KITTITAS COUNTY

DEPARTMENT OF PUBLIC WORKS

MEMORANDUM

TO: All Staff
FROM: Public Works Plan Review Team
DATE: October 1st, 2024
SUBJECT: SPF-24-00007 Mohar-Updated 10/28/24

MOHAR FARM SHORT PLAT

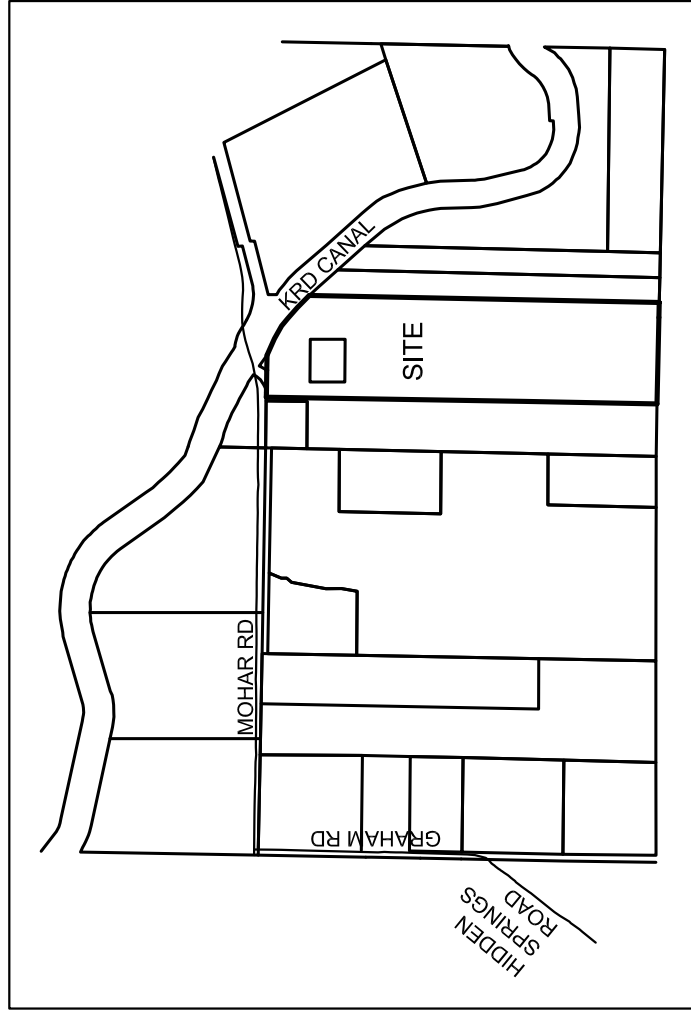
FLOOD	No comments. (SC)
WATER MITIGATION/ METERING	<p>A plat note must also be added for the conservation easement:</p> <p>LOT 3 OF THIS SHORT PLAT HAS BEEN PLACED IN A CONSERVATION EASEMENT RECORDED UNDER AFN 202409250024, THAT STATES LOT 3 SHALL BE USED FOR OPEN SPACE AND NO DOMESTIC WATER CONSUMPTION OR USE SHALL OCCUR. SEE DOCUMENT FOR FULL DETAILS.</p> <p>Please also include a note on the face of the plat in lot 3 that states: see short plat note <u>(insert number here)</u></p> <p>UPDATE October 24, 2024 Requirements have been met. No further comments. (SC)</p>
AIRPORT	No comments. (JS)
